23 November 2010

**Major Project 10_0107 – Residential Development – Buildings 1, 2 & 3
61 Mobbs Lane - Epping - Channel 7 Site (Epping Park)**

Project Application  
 A-3103

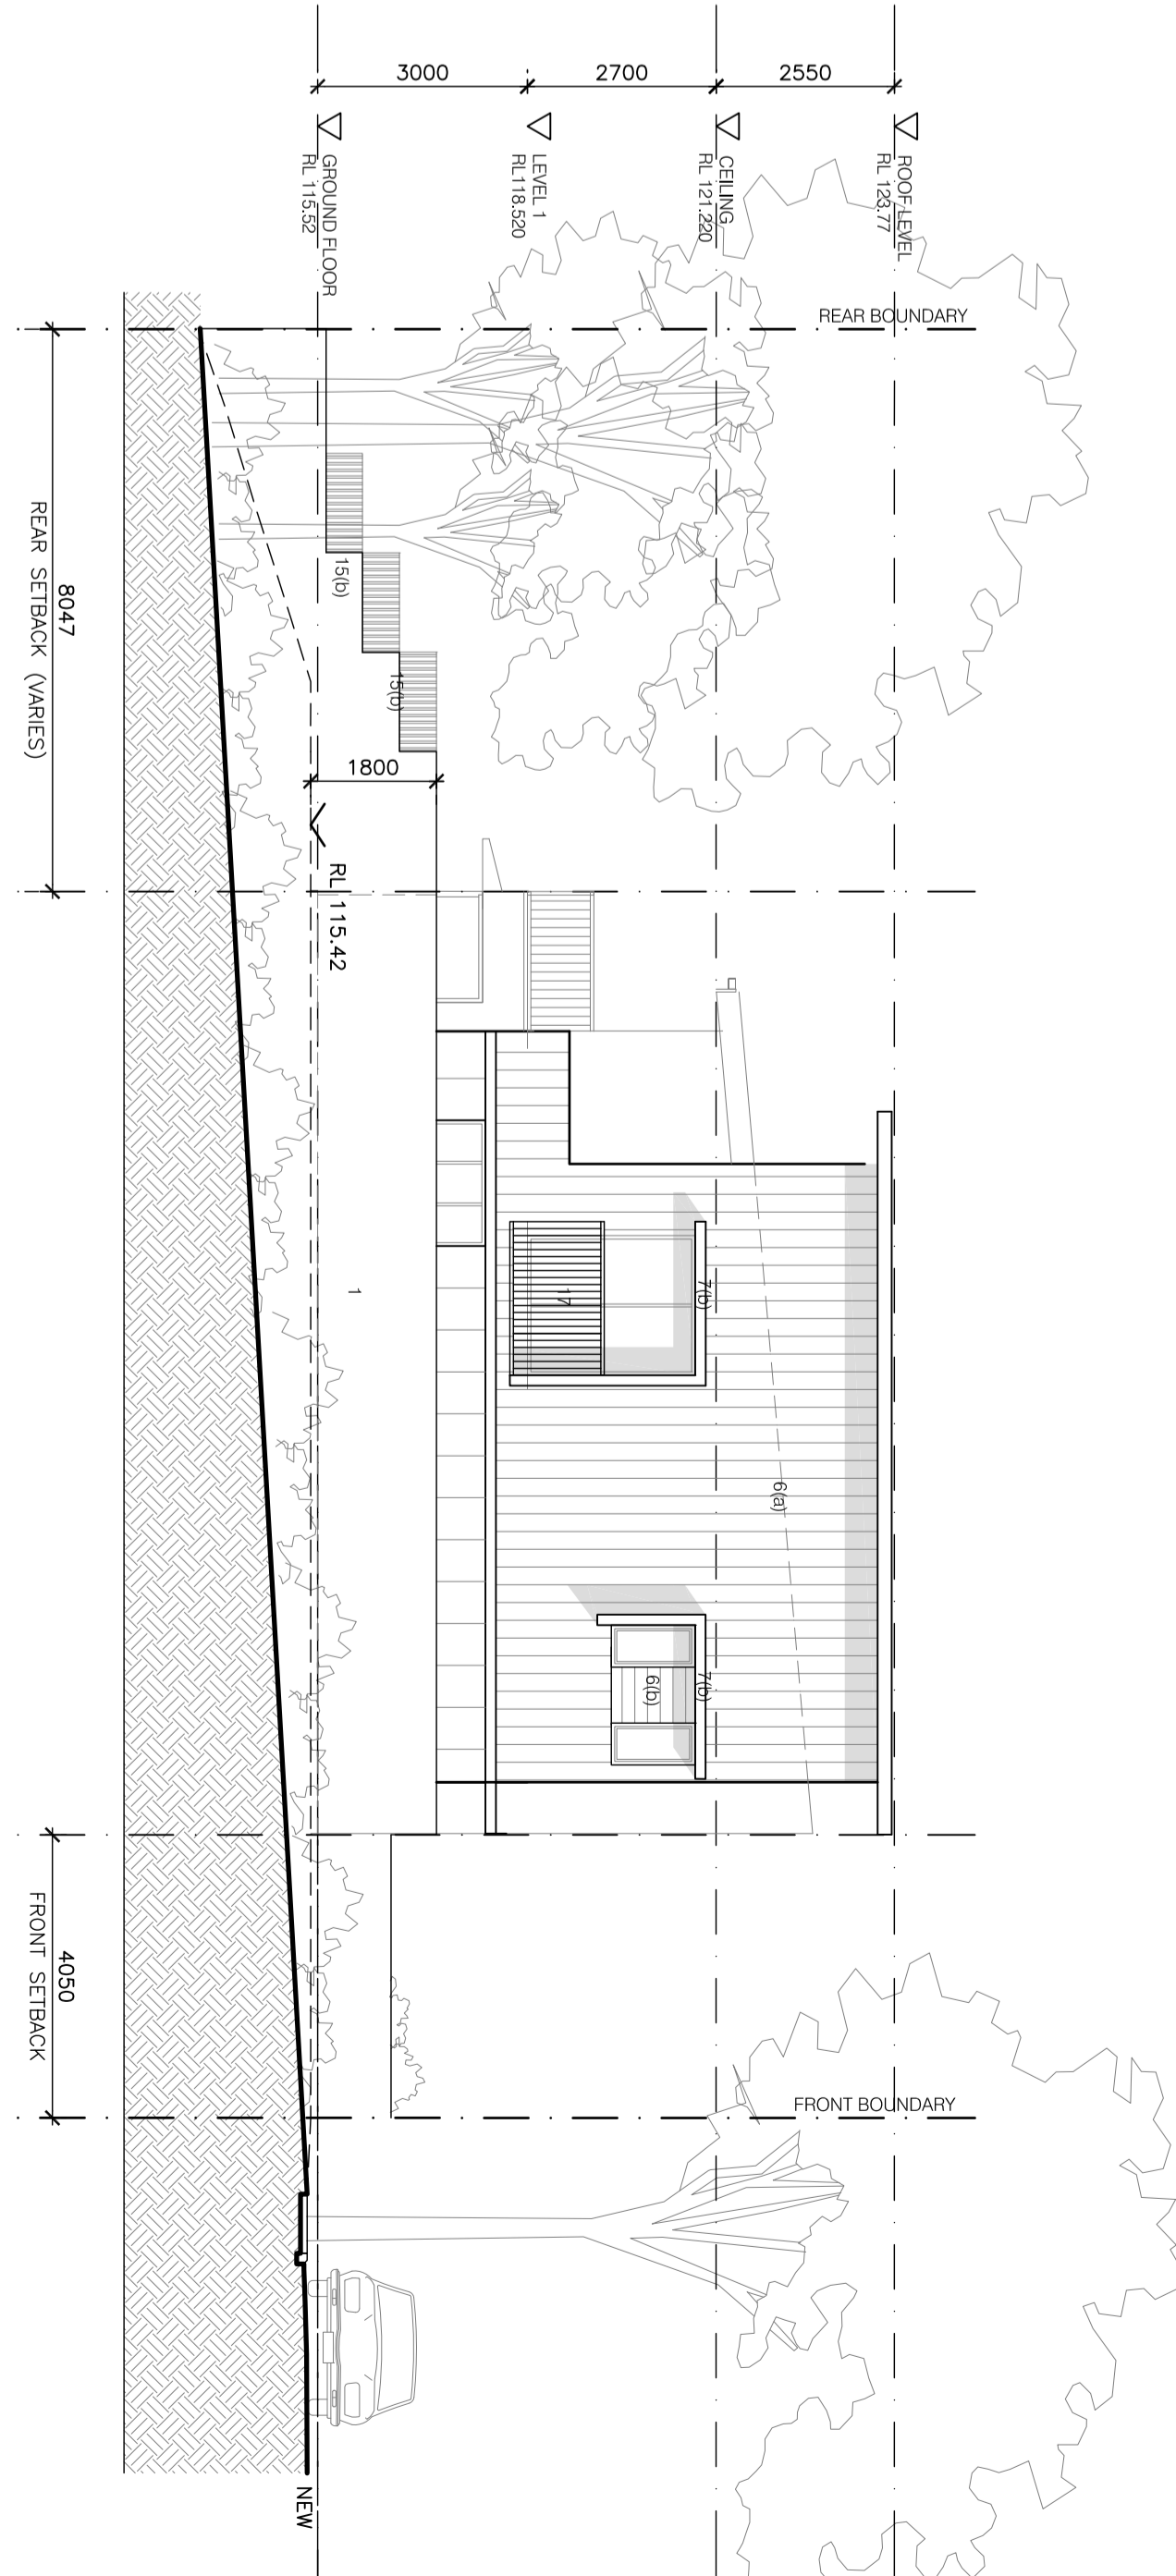
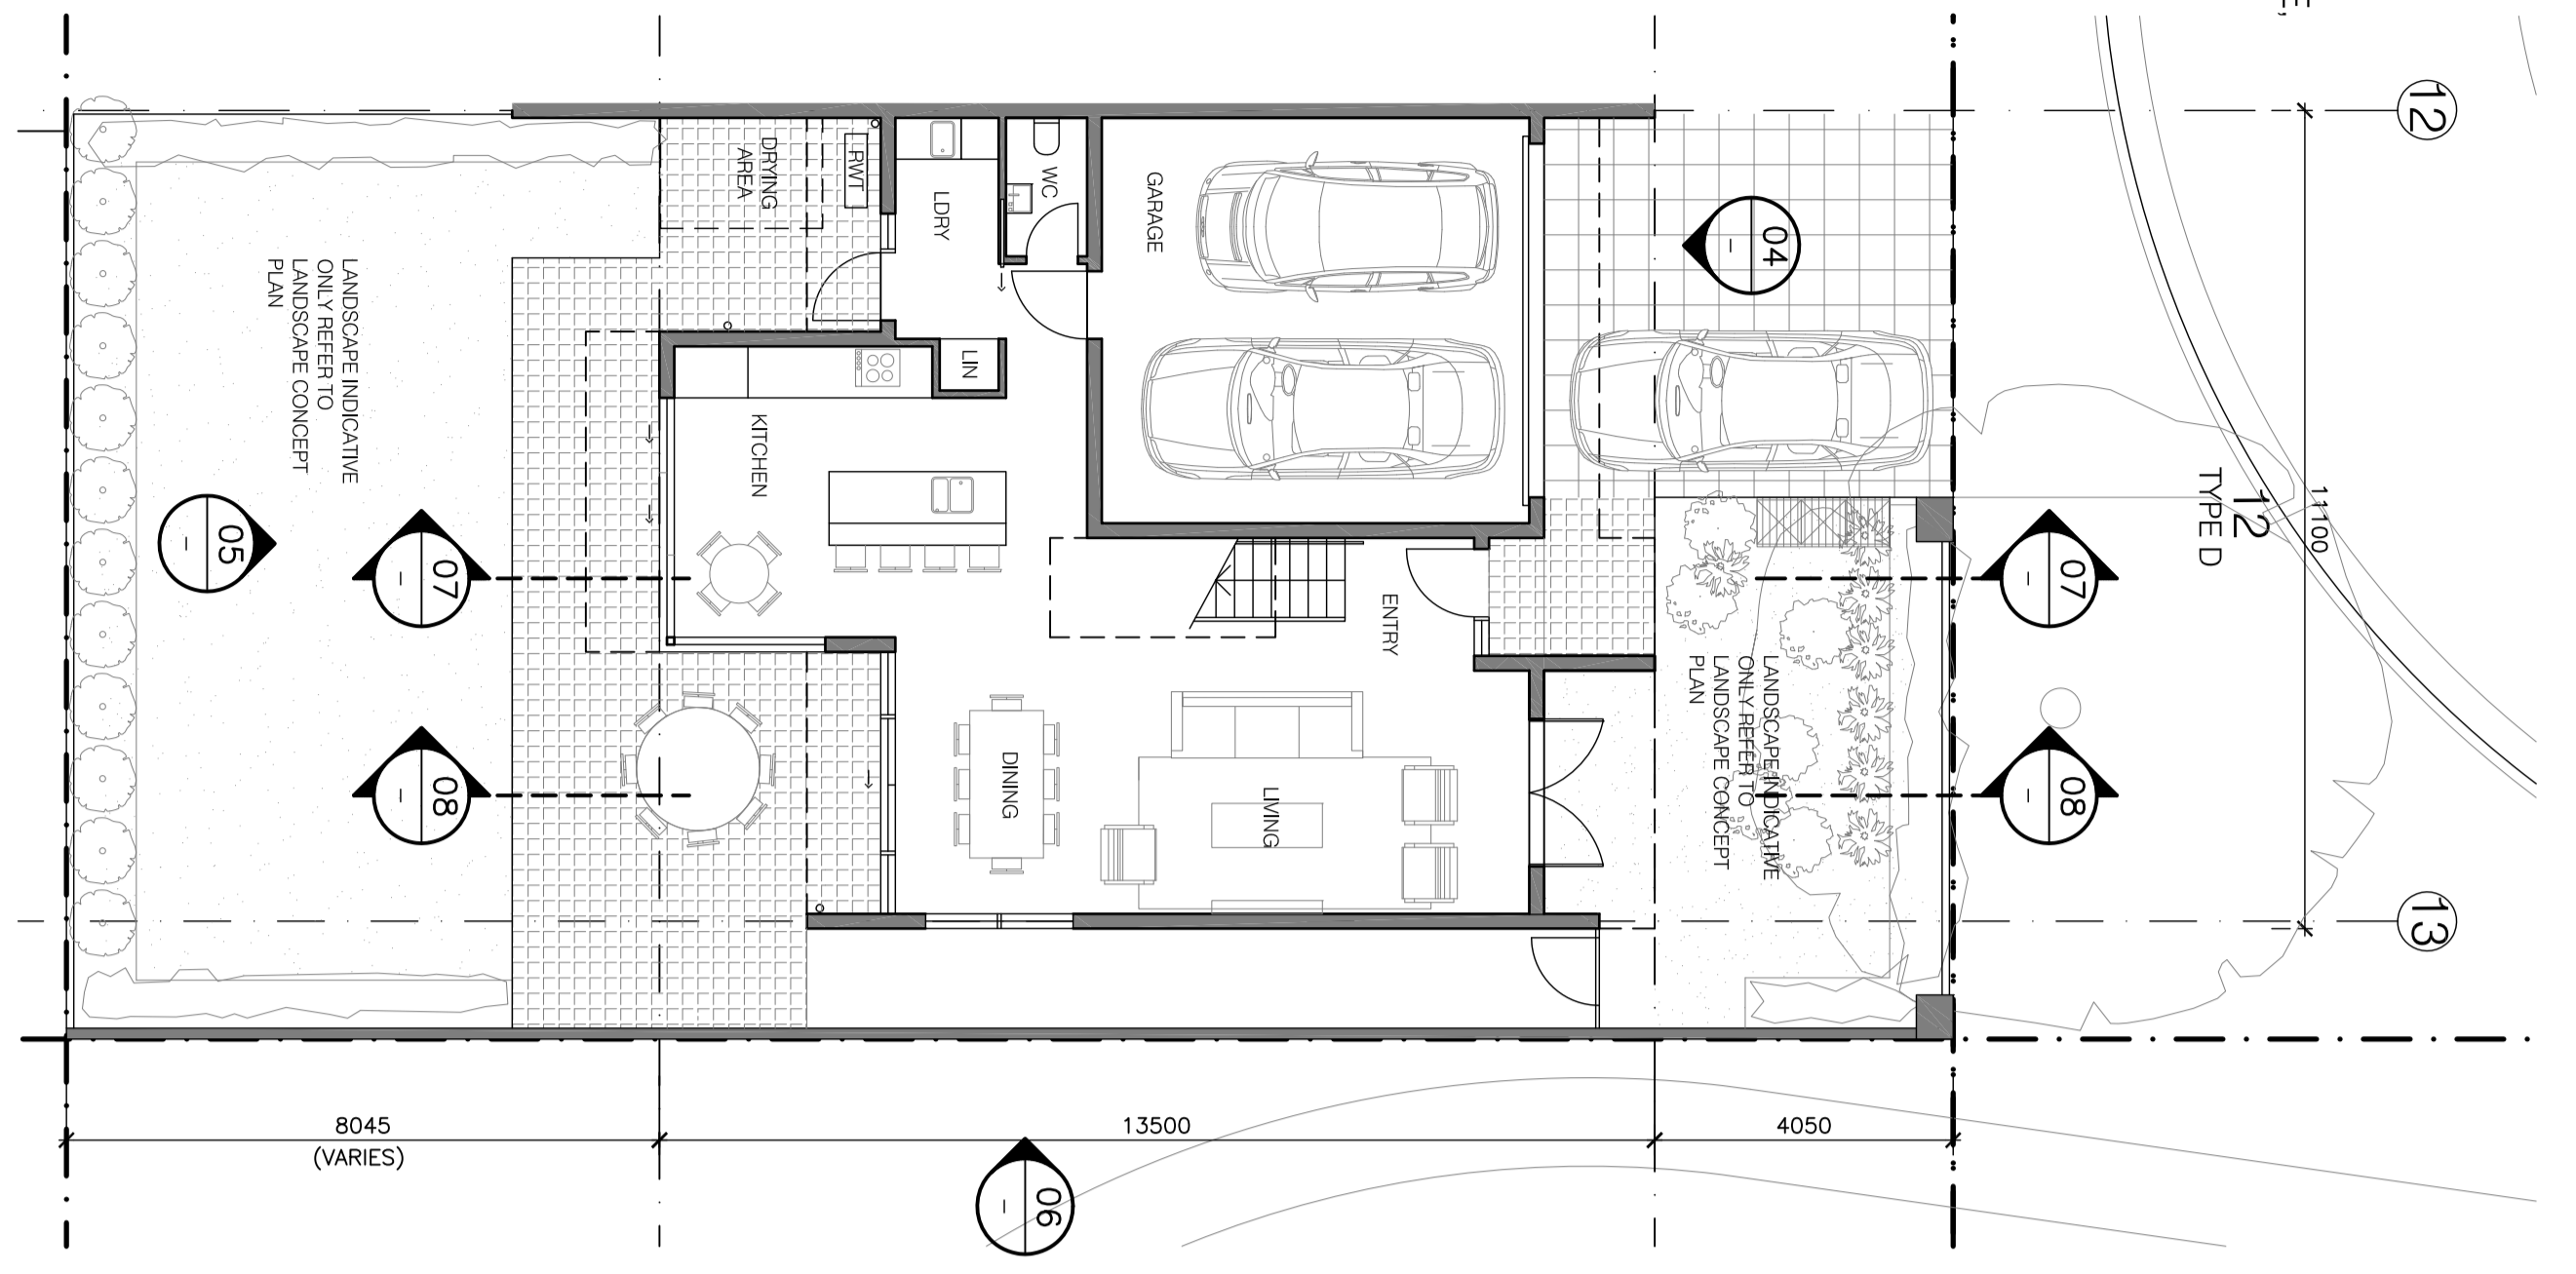
The reproduced Concept Plan is of poor quality and it is unclear if a 6.7m or 8.7m is required to the eastern property boundary adjoining the rear yards of the detached dwellings. The proposal provides a varying rear setback to building 3 of approximately 8m. Clarification is sought about the setback required under the approved Concept Plan to the eastern boundary. If the setback is 8.7m, the proposal should be amended to comply with this requirement to protect the amenity of the adjoining properties, provide greater private open space and landscaping.

The height controls for building 3 within the approved Concept Plan indicates a transition from 2 storeys to single storey towards the eastern site boundary. The application proposes a largely 2 storey building form with a limited single storey component. The proposal also includes roof elements that extend up to 2.75m above the upper level ceiling height for architectural articulation of the long linear building form. This appears excessive and unnecessary.
